London Luton Airport Expansion

**8.118 Applicant's Response to Issue Specific Hearing 4 Action 7 –
Update on Road Safety Audits**

Deadline:	Deadline 85
Planning Inspectorate Scheme Reference:	TR020001
Document Reference:	TR020001/APP/8.118
Author:	Luton Rising

Version	Date	Status of Version
Issue 1	November 2023	Additional Submission – Deadline 5
Revision 1	January 2024	Additional Submission – Deadline 8

16.5m Articulated HGV  
Swept Paths At Junction 10  
of the M1 with 2039  
27mppa Mitigation Scheme  
Scale 1:1000 at A1  
Drawing Number - SK053

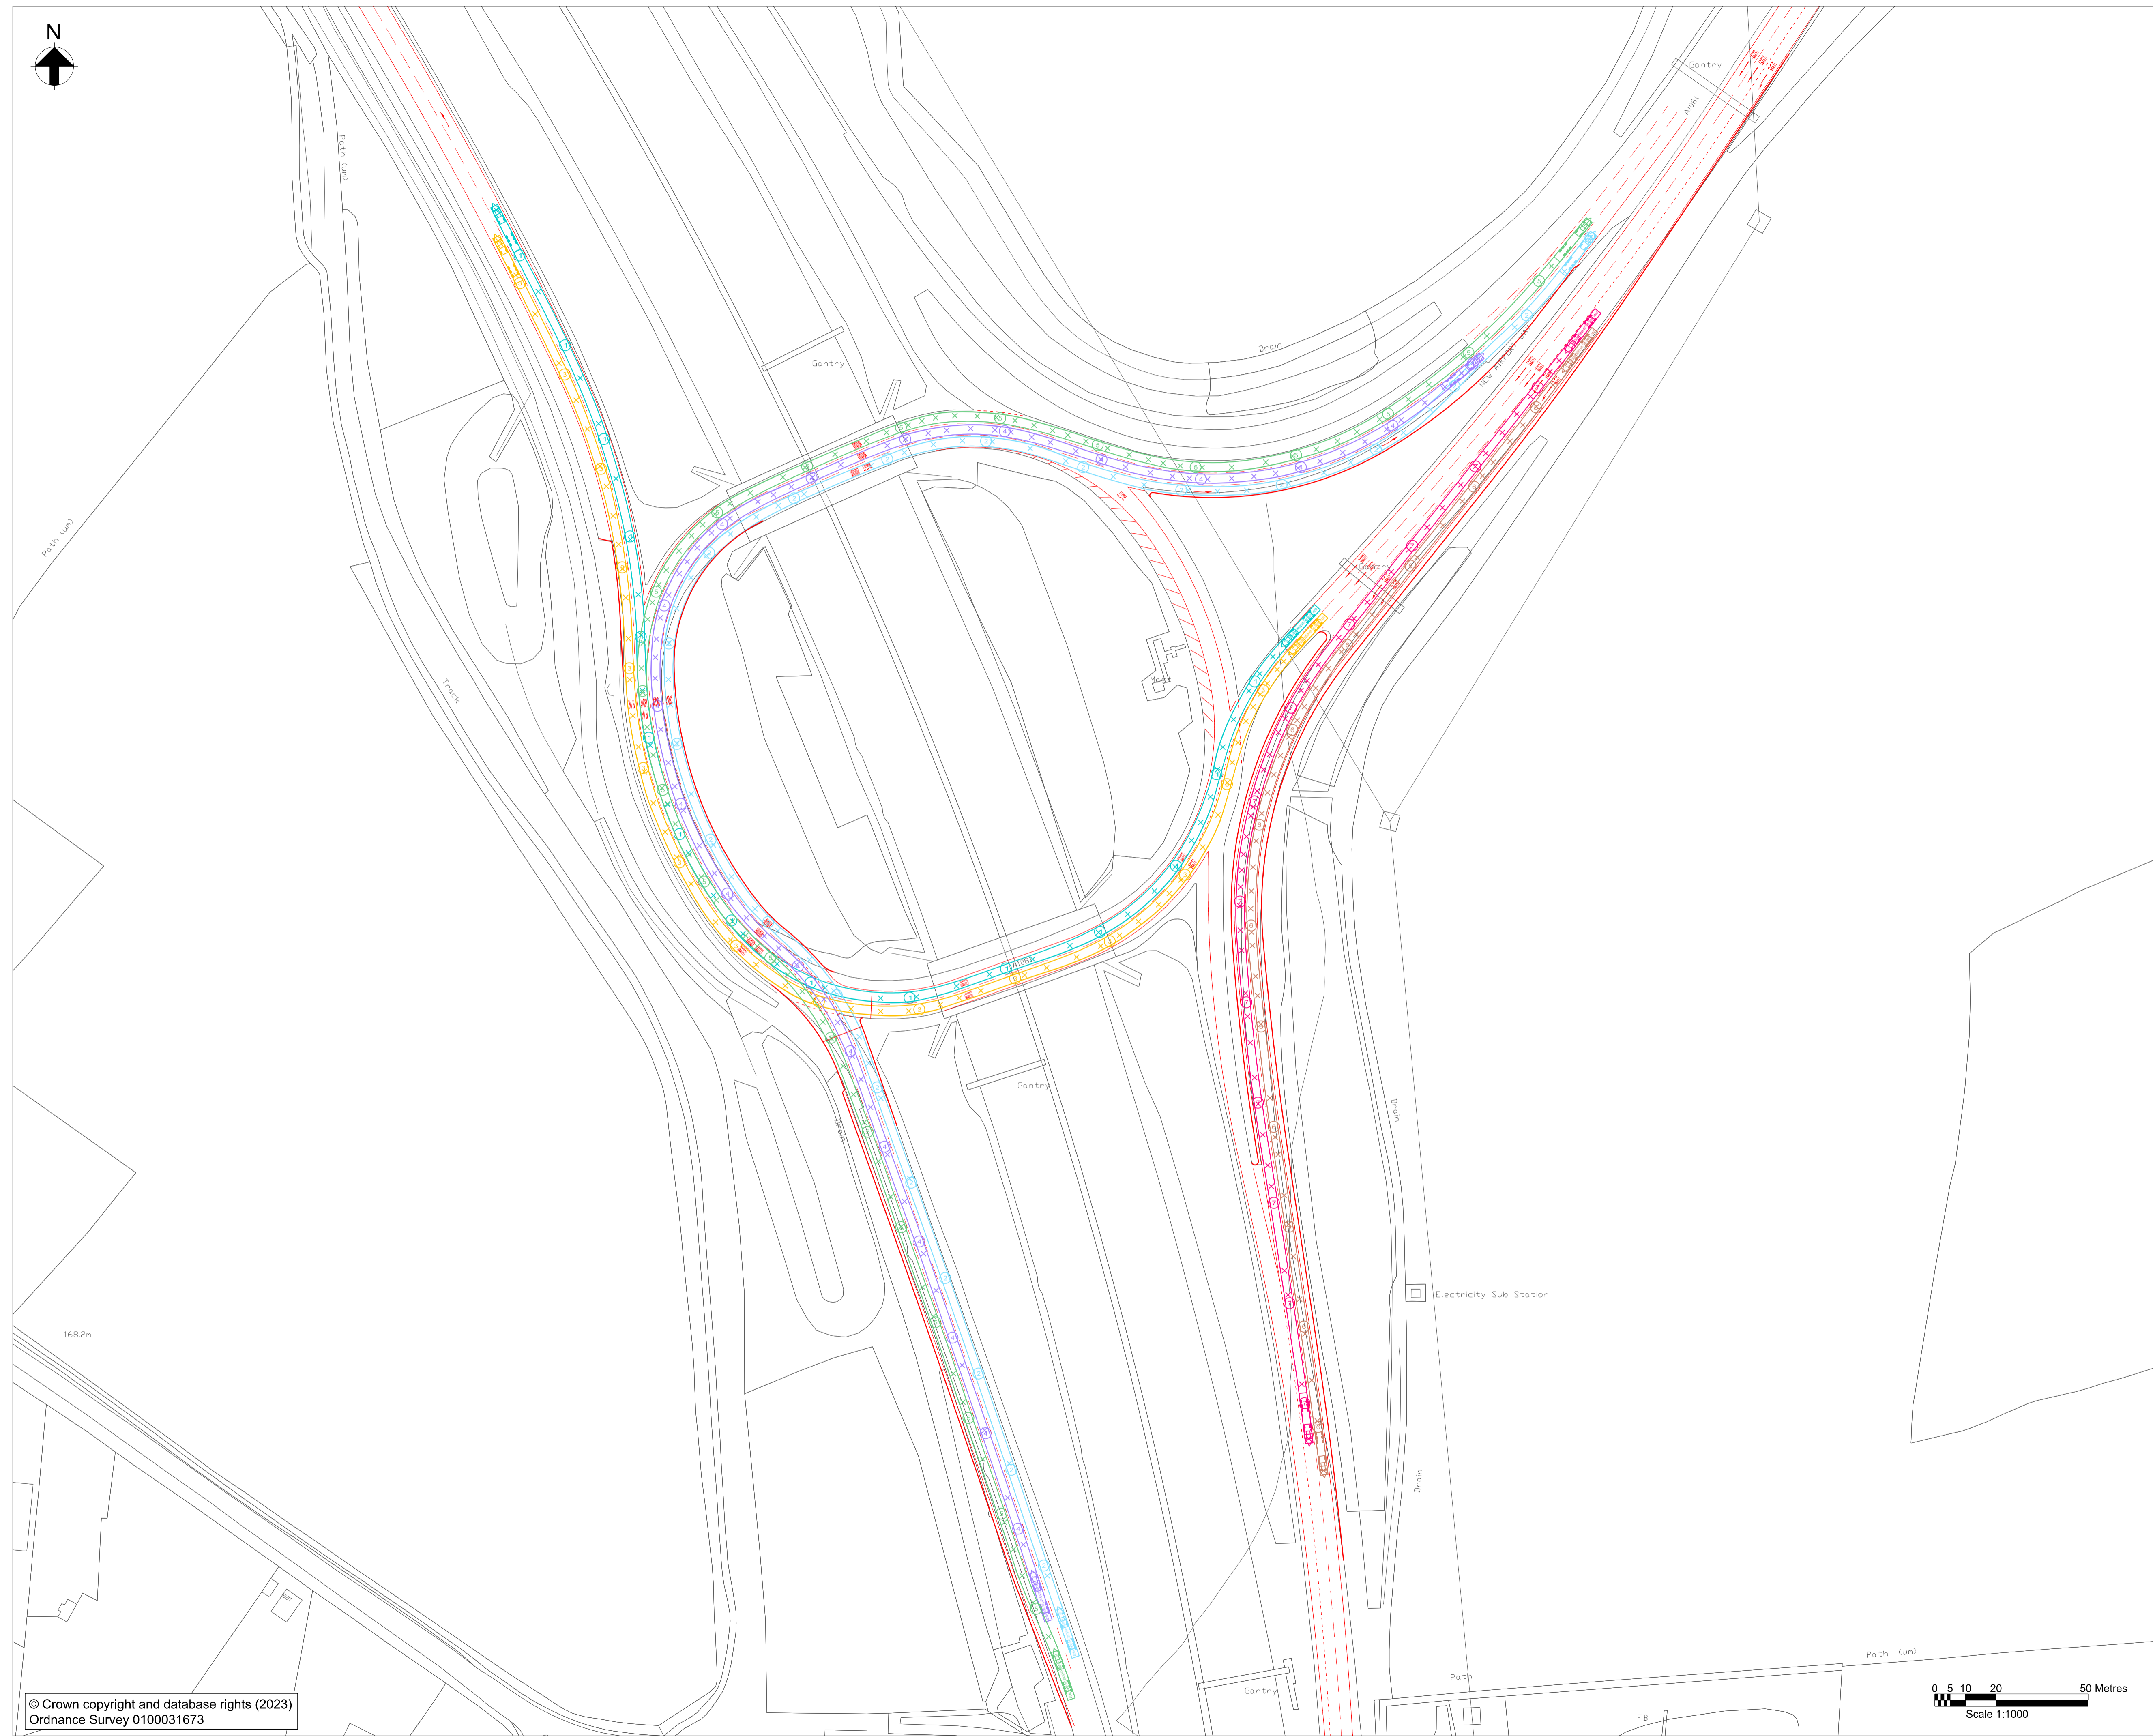
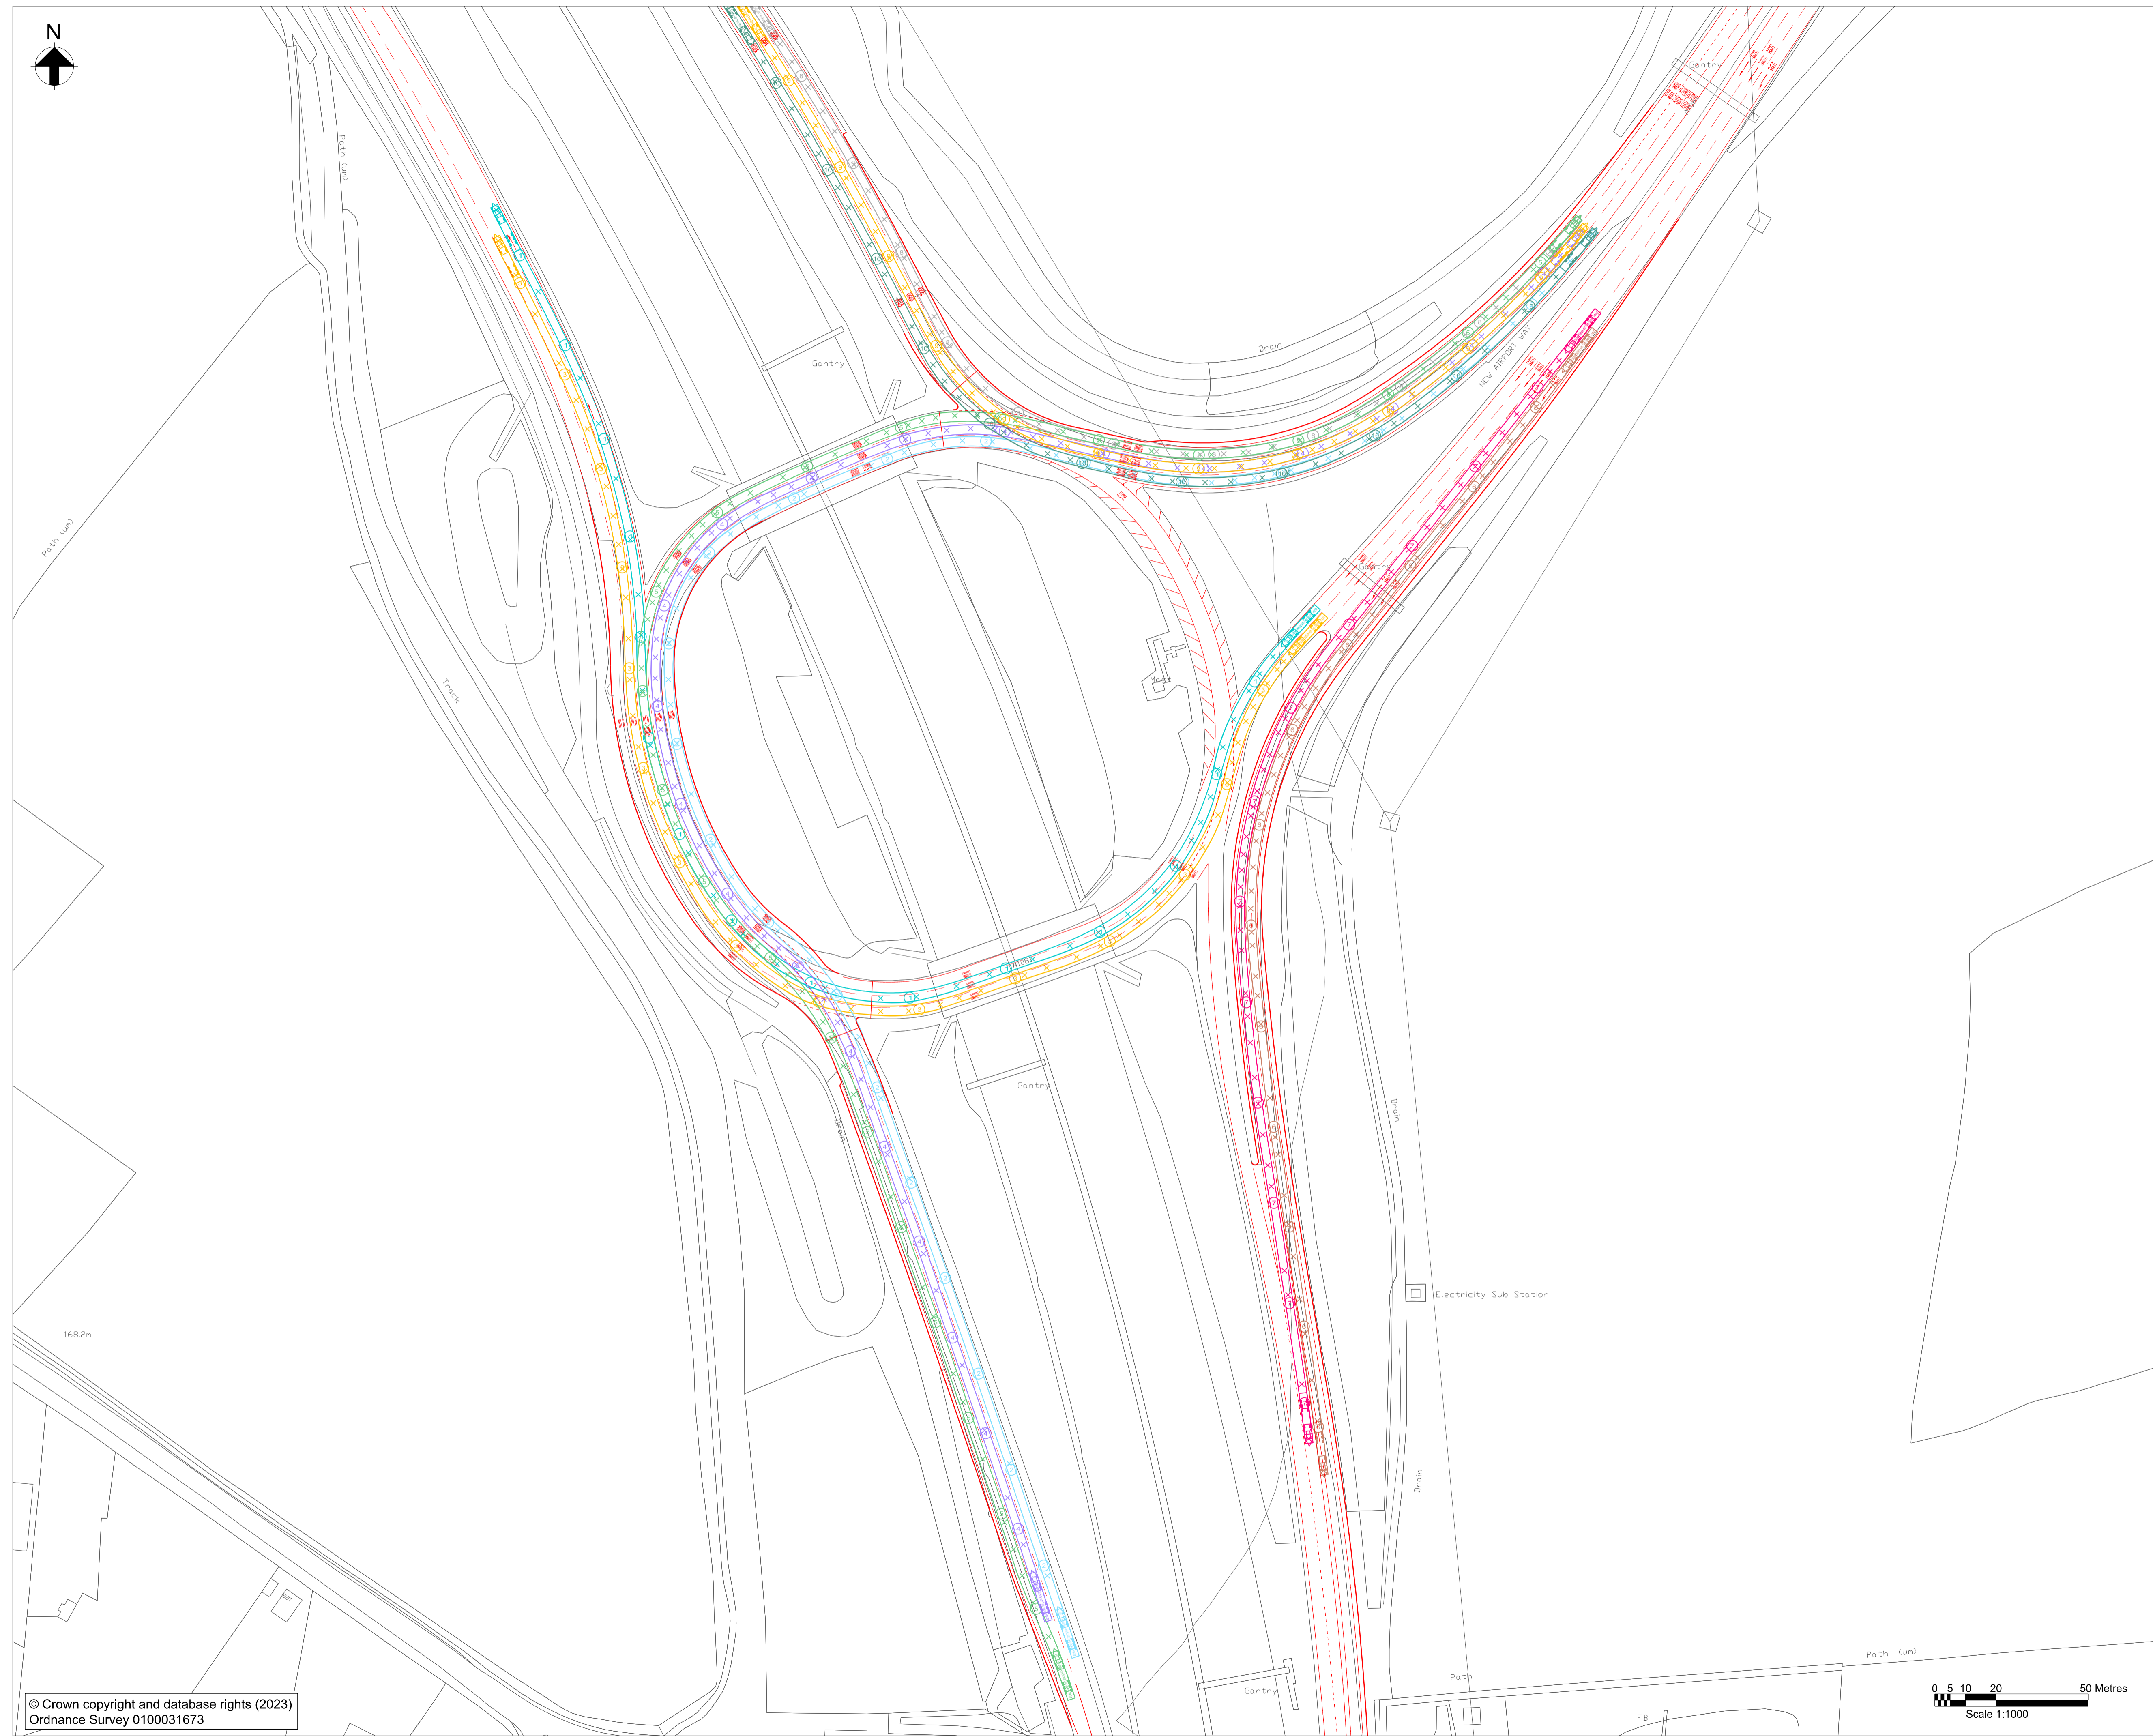
Ref.	RSA Problem	RSA Recommendation	Design Organisation Response	Overseeing Organisation Response	Agreed RSA Action
3.1	Drawing LLADCO-3C-ARP-SFA-HWM-DR-CE-0009 indicates that the length of the two-lane merge is to be extended by 150m. This may result in forward visibility of the merge point being compromised by an existing hidden dip in the northbound on-slip. This problem increases the risk of side swipe and loss of control type collisions.	Ensure that sufficient forward visibility of the merge is maintained.	Accepted. Forward visibility would be checked at the detailed design stage to ensure that appropriate visibility of the merge is maintained.	National Highways agree with the RSA. Traffic on the slip will be visible but the designer has agreed to checks.	Forward visibility would be checked at the detailed design stage to ensure that appropriate visibility of the merge is maintained.

3.2	The brief provided for Road Safety Audit did not identify any departures from standard, however an offside merge has been proposed on the southbound on-slip in both phases 2a and 2b. This arrangement may increase the risk of road user confusion and it may be difficult for road users to merge into the segregated left turn lanes coming from the A1081. Road users may slow or stop when trying to merge increasing the risk of shunt type collisions with other road users heading southbound from the roundabout or shunt, sideswipe and loss of control type collisions with road users in the segregated left turn lanes.	Rearrange the proposed junction arrangement to eliminate the off-side merge.	Accepted. The proposed design of the merge could be amended to be a nearside merge. Alternatively, the exit lane off the circulatory could be removed as this would only serve errant vehicle movements i.e. M1 'U' turners or southbound vehicles that exit at J10 and then rejoin the M1 southbound carriageway. Almost all the vehicles using the southbound on-slip would be from the A1081 and would use the	National Highways agree with the RSA. The alternative designers response could hinder low numbers of U-turners and lead to erratic / late braking manoeuvres so suitable signing would need to be provided to inform road users of the route required to re-join the M1. Merging into the offside can also result in slower moving traffic that would typically be in lane 1 (HGV) needed to merge into potentially faster moving traffic,	NH comments on the alternative noted and any amendment to the design would be supported by appropriate amendments to the signage. NH comments on merging noted however the arrangements proposed by the Auditor and accepted by the Design Organisation are in keeping with the existing arrangements at the junction.

3.3	<p>In Phase 2a and Phase 2b a two lane segregated left turn from the A1081 onto the M1 southbound slip road has been proposed. The existing southbound lane from the M1 J10 roundabout is proposed to join the segregated lanes with a short length of off-side merge. No details regarding infrastructure or stopping sight distances have been provided. Items such as VRS and signs between the segregated left turn lanes and off-side merge may obscure visibility for road users. This issue may increase the risk of side swipe, shunt, and loss of control type collisions. This</p>	<p>Provide sufficient intervisibility between the merge and segregated left turn lanes.</p>	<p>Accepted. See above response to Item 3.2 regarding the design or removal of the merge. If the exit off the circulatory is retained, there is scope to amend the alignment of the segregated left turn and separating island in order to accommodate potential VRS, signage and visibility requirements. This would be addressed at the detailed design stage.</p>	<p>National Highways agree with the RSA.</p> <p>It would be interested to explore the potential for closing the eastern circulatory or S/B merge exit as mentioned. That could remove a couple of issues, but signing for route finding would be key.</p>	<p>Amend the alignment of the segregated left turn and separating island in order to accommodate potential VRS, signage and visibility requirements. This would be addressed at the detailed design stage.</p> <p>The opportunity to close the eastern circulatory or southbound merge will be considered at the detailed design stage.</p>

3.4	<p>In Phase 2a a two-lane segregated left turn from the A1081 onto the M1 southbound slip road has been proposed. The existing southbound lane from the M1 J10 roundabout is proposed to join the segregated lanes with a short length of off-side merge, this merge is followed immediately by a section of informal two-lane merge in advance of joining the main carriageway on the M1. Insufficient road space for the merges may increase the risk of side swipe and loss of control type collisions.</p>	<p>Ensure that sufficient road space is provided for road users to safely merge.</p>	<p>Accepted. See above response to Item 3.2 regarding the design or removal of the merge. It is noted that the proposed amendments to the white lining south of the offside merge increase the width of the on-slip as well as the overall merging length with the mainline by some 175m. The width of the slip is sufficient to extend the white lining to formalise the two lane section beyond that shown on the existing drawings and to extend the two lane section prior to the secondary merge. This can be addressed as part of the detailed design.</p>	<p>National Highways agree with the RSA.</p>	<p>As part of the detailed design amend white-lining to maximise the length of the two lane section.</p>
